Application Reference: 2025/0716

Site Address: High Royd Farm, High Royd Lane, Hoyland, Barnsley, S74 9NW

Introduction: Erection of a single storey detached garage

Ref.	Dwg. No.	Rev.
2025/79	04	B

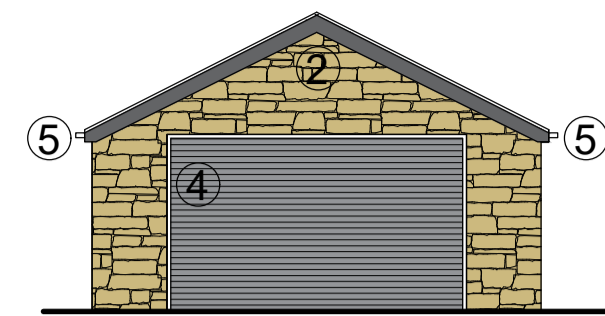
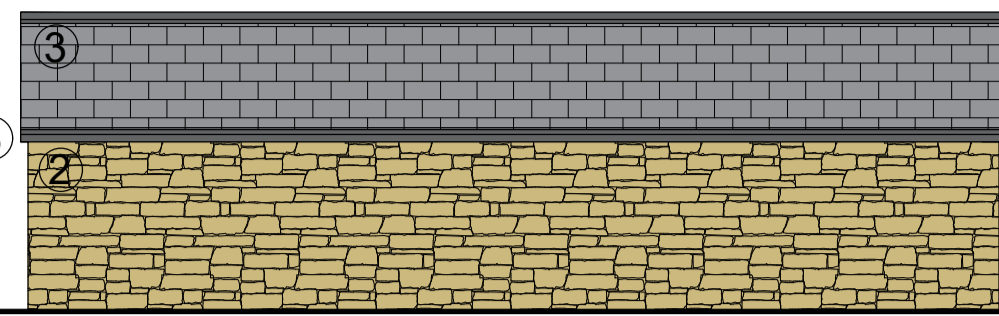
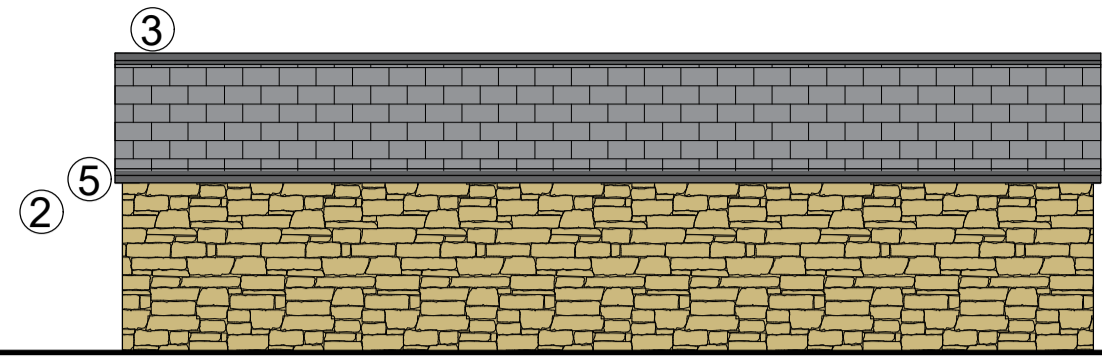
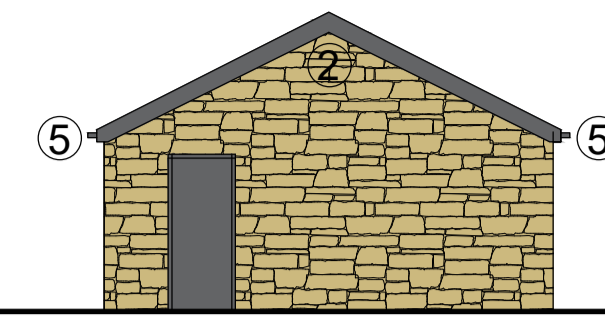
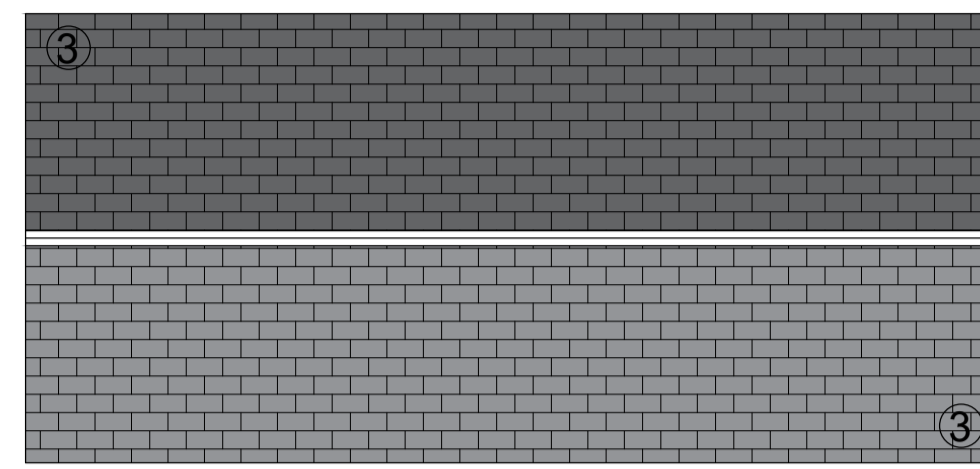
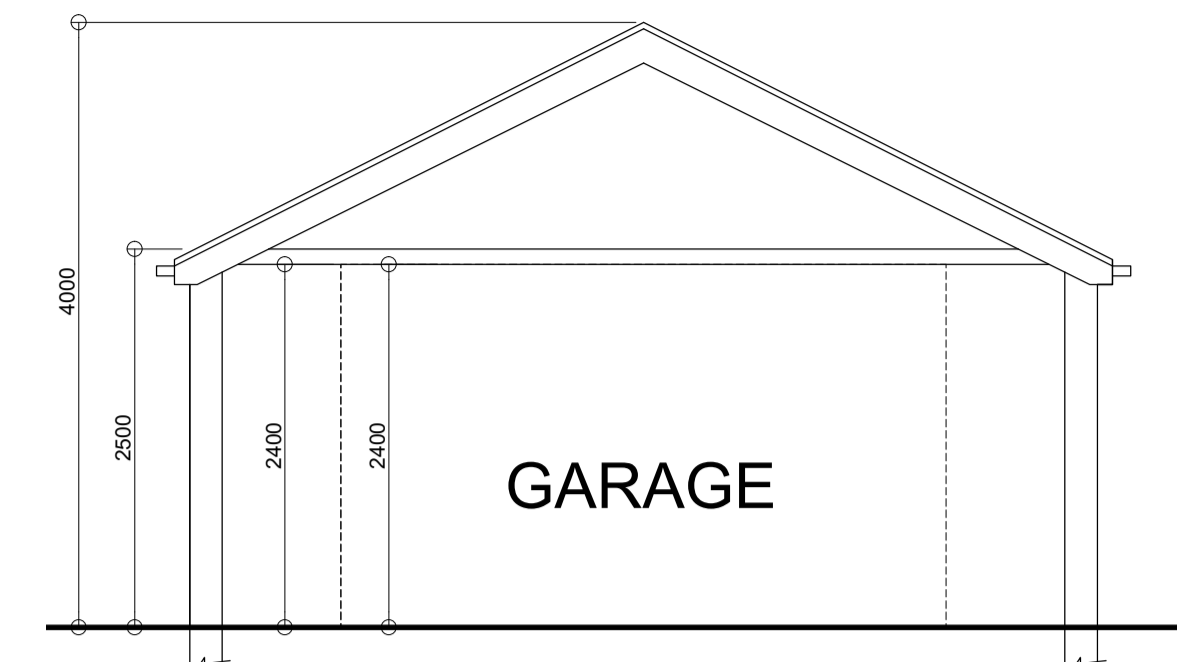
The proposed garage provides a ridge and eaves height which is considered acceptable and aligns with the House Extension SPD. The length of the garage is considered substantial at 13 metres, double the length of a standard double garage. However, given the size of the site, the floor space of the garage would be proportionate and remain subservient to the host dwelling and its curtilage. Furthermore, large incidental outbuildings could be built under permitted development rights within the curtilage of the property. A condition will be recommended to restrict the use of the garage to ensure it remains for domestic garaging use.

The use of a gable roof form is preferred and allows the style of the garage to be in keeping with the site and neighbouring buildings. The use of stone and blue slate is welcomed and also allows the proposal to remain in keeping with the site and surrounding properties.

It has been necessary to make contact with the applicant to reduce the ridge height of the garage down to an acceptable level of 4 metres. These amendments were received on the 18th December 2025

Garage Plan & Elevations & Site Plan as Proposed 2025/79 DwgNo:04 Rev:B
